CONSULTEE RESPONSE (Council's Arboriculturist)

Reference: BN/59/22/T

Location: Land Southeast of Halliford Drive, Barnham, PO22 0FB

Proposal: 1no. poplar tree (T3) - remove 1 stem overhanging neighbouring property (26 Songthrush Lane) on eastern side of canopy. 1no. poplar tree (T4) - reduce height by approx. 2-3m to leave approx. 12m. 1no. alder tree (T8) fell to ground level

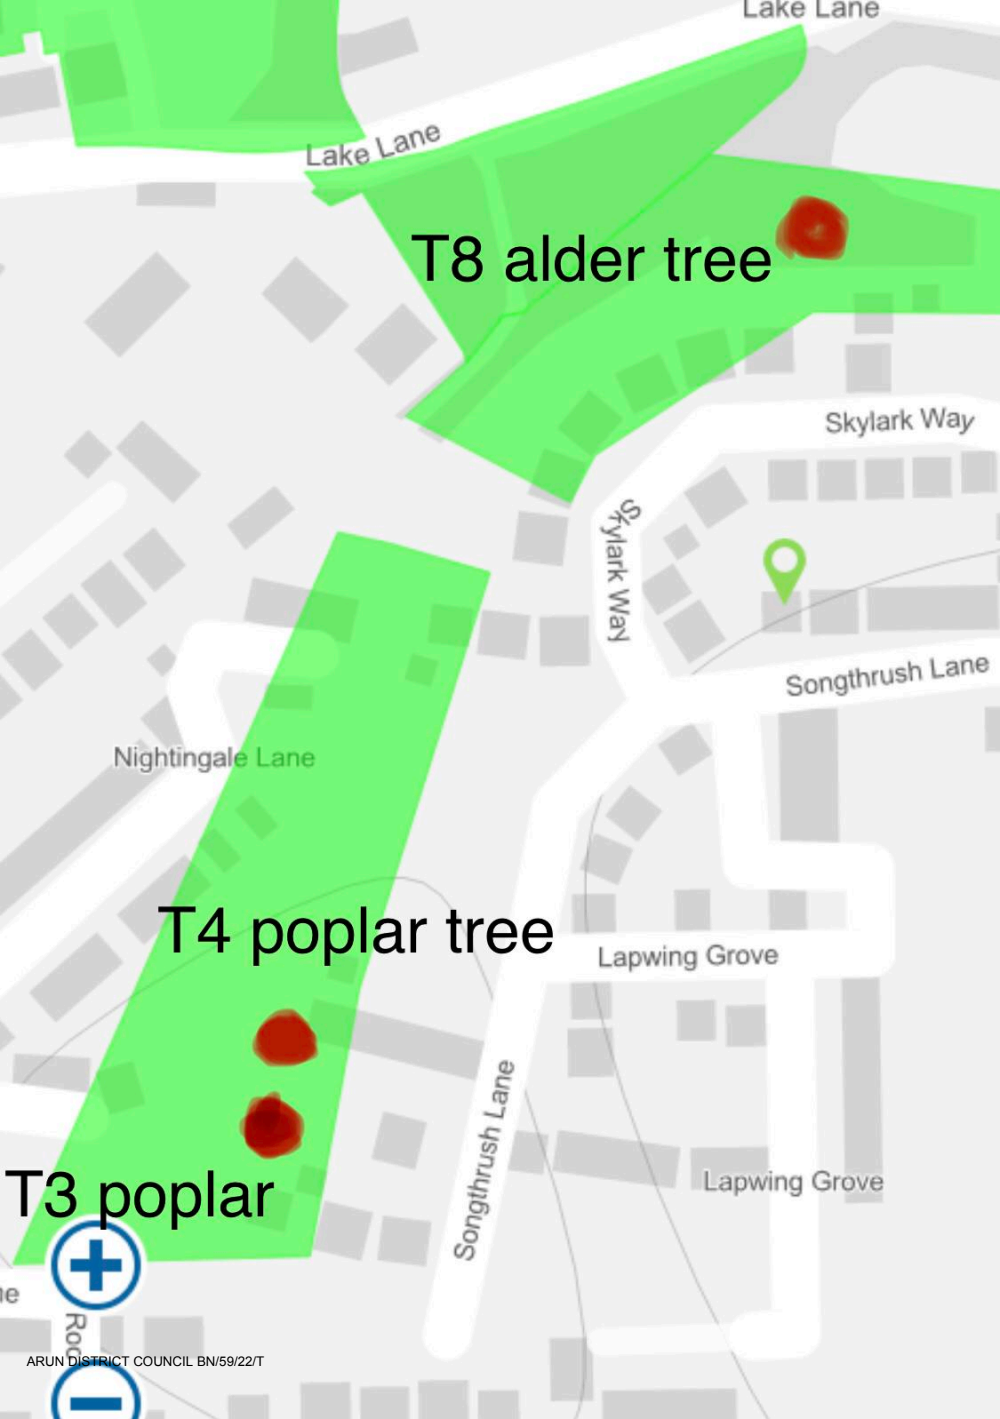
T3 – Twin stem tree, one of which leans acutely over private garden. High growth potential = accelerating risk of failure.

T4 – Four separate tree stems forming a broadly cohesive crown. No evidence provided to justify pre-emptive pruning work that would introduce structural weakness across the branch framework at height.

T8 – Heavily suppressed arching stem that presents an unacceptable level of risk for the location.

The work proposed for items T3 and T8 is justified on arboricultural grounds. T8 does not require a replacement due to the density of the group and difficulty establishing.

T4 is a cluster of highly visible trees which collectively form an impressive group. Safety concern for nearby residents is commendable and it is encouraging the tree owner has instructed a professional arborist to

As it stands, I am unable to support this application. **I would like the applicant to be invited to agree to a revised proposal for lesser works by removing T4 from same, as part of the current application so as not to incur further delay.**
